December 22, 2025

Re: Fire Station 12
11701 Central Ave NE
30-Day Temporary Certificate of Occupancy
Transportation Development Final Inspection
Architect's Stamp dated 08-30-24 (L21-D036)
Certification dated 11-18-2025

RE: FIRE STATION #12 - 11701 CENTRAL AVE NE.
PERMIT # BP-2024-33315

A1 SITE PLAN

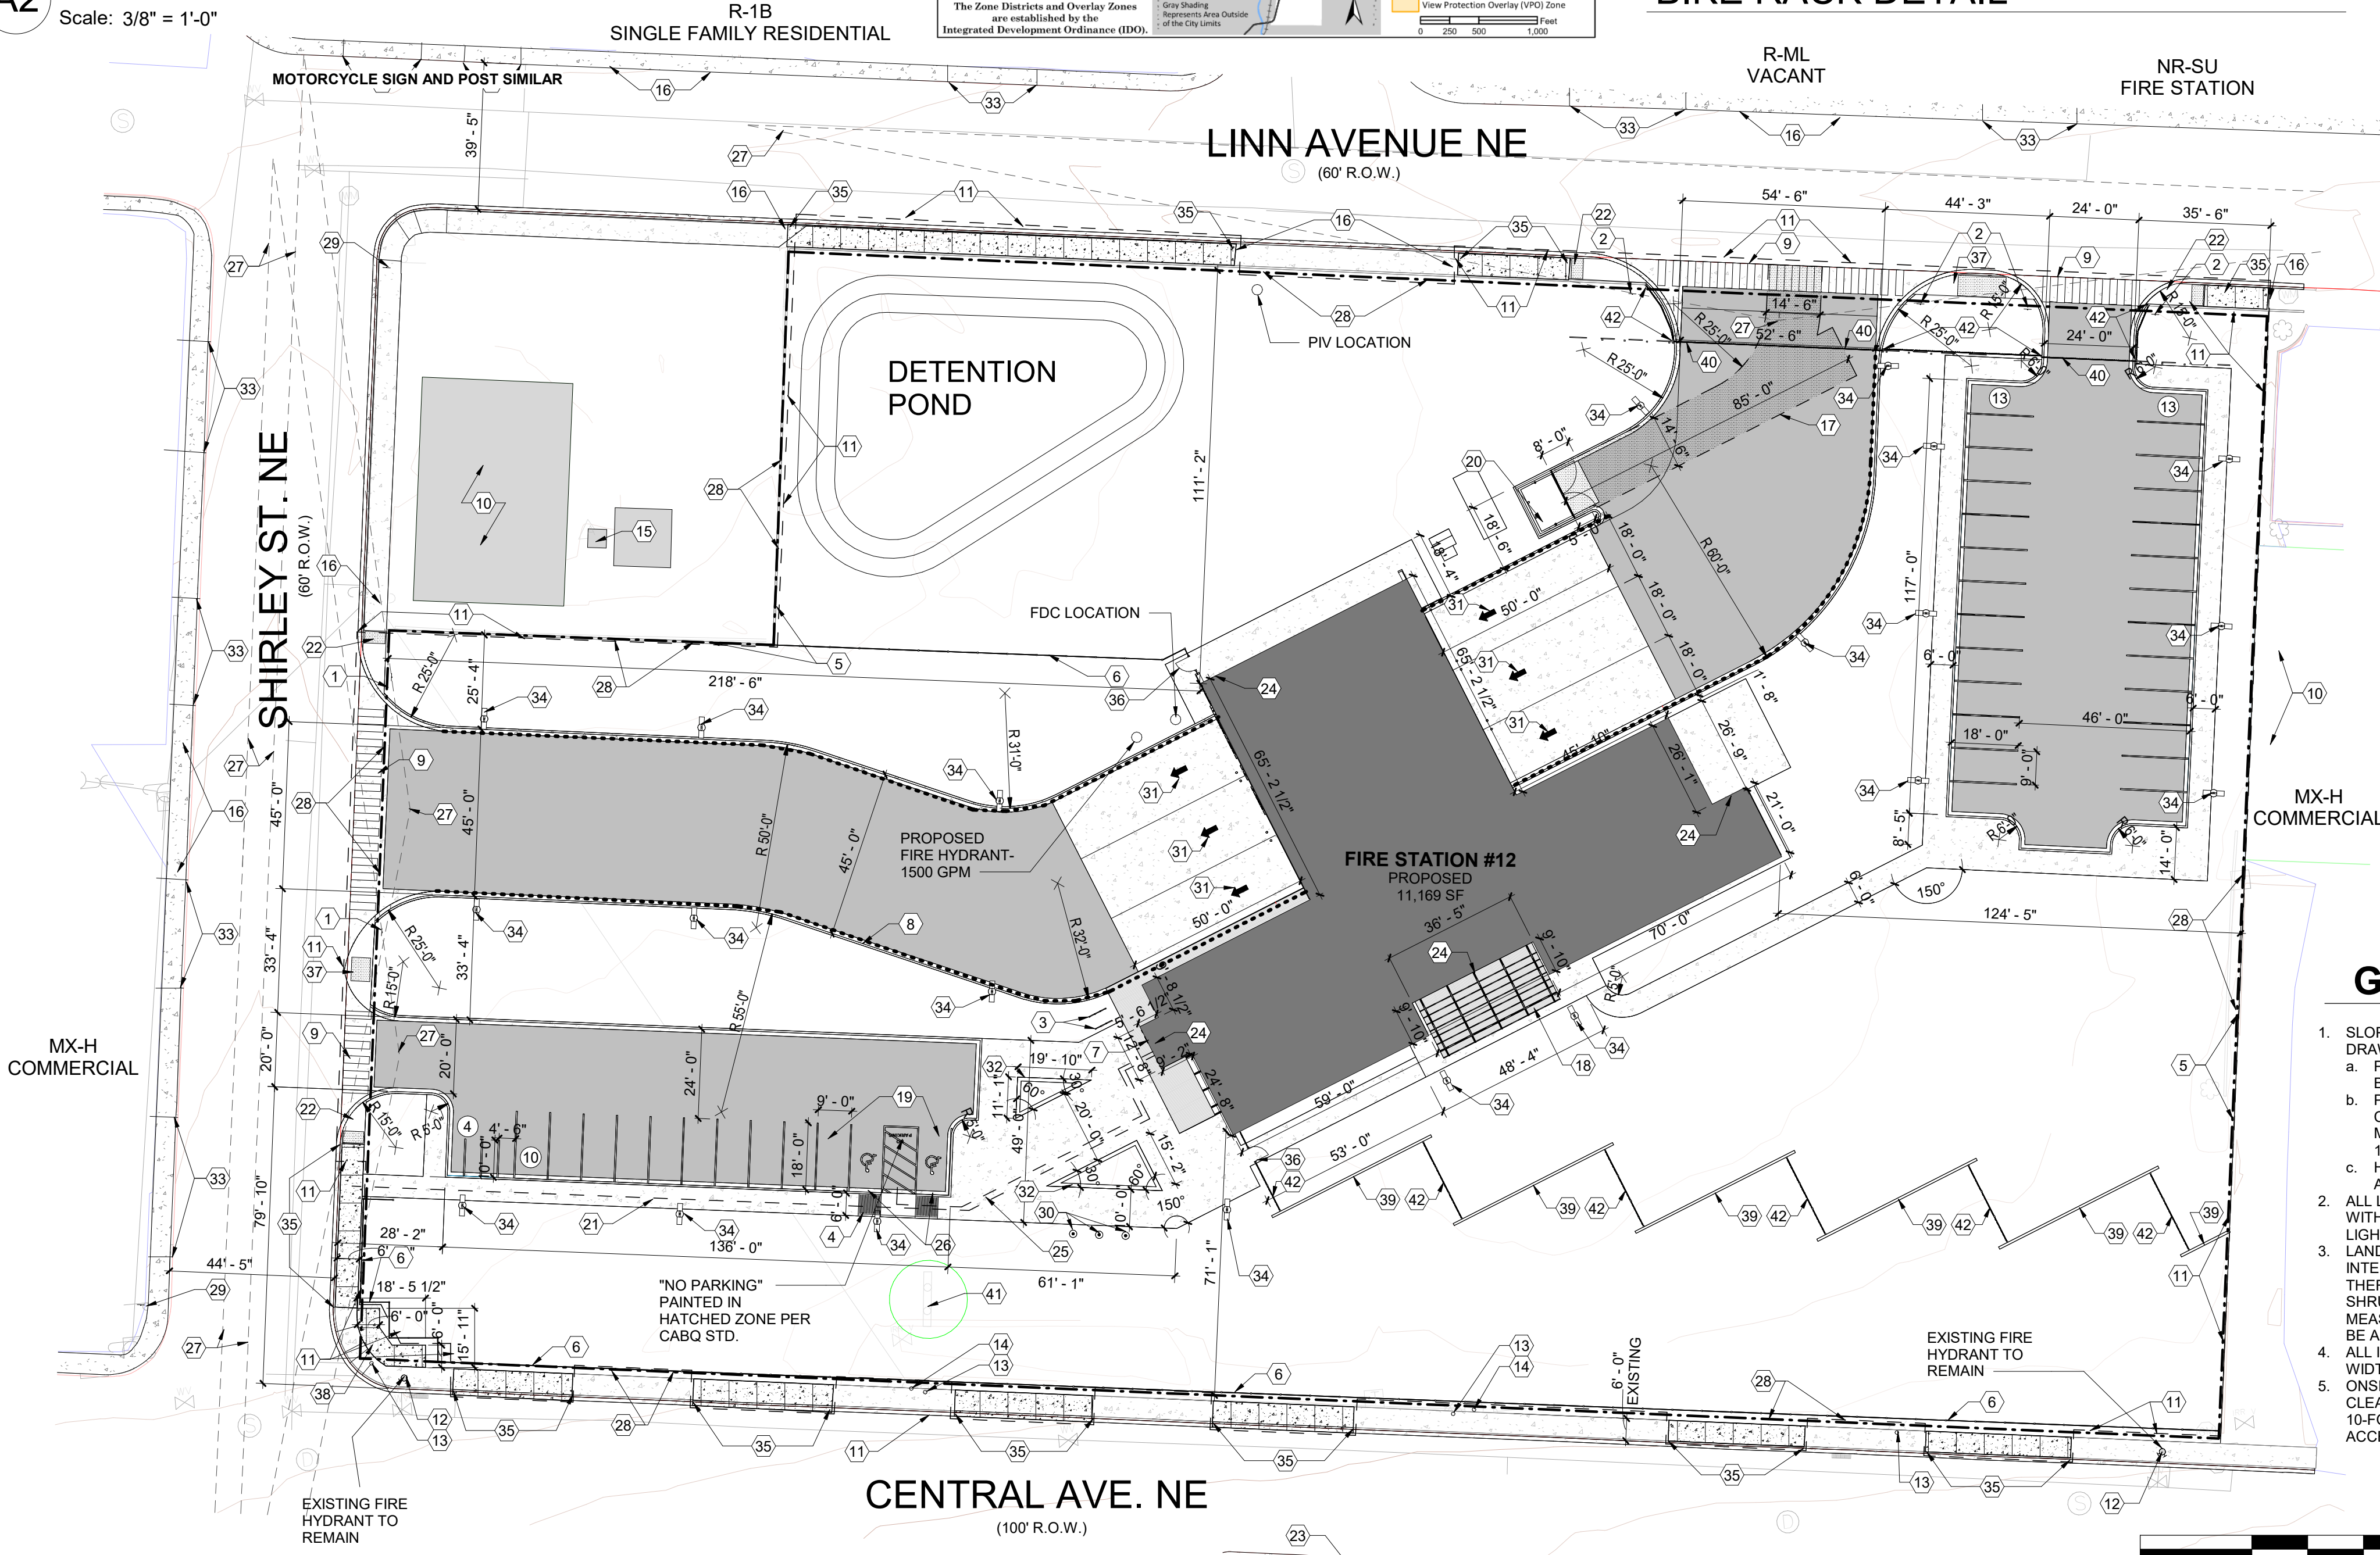
- A Truncated Domes must be installed at the ADA ramp at the corner of Central Ave. and Shirley St NE.
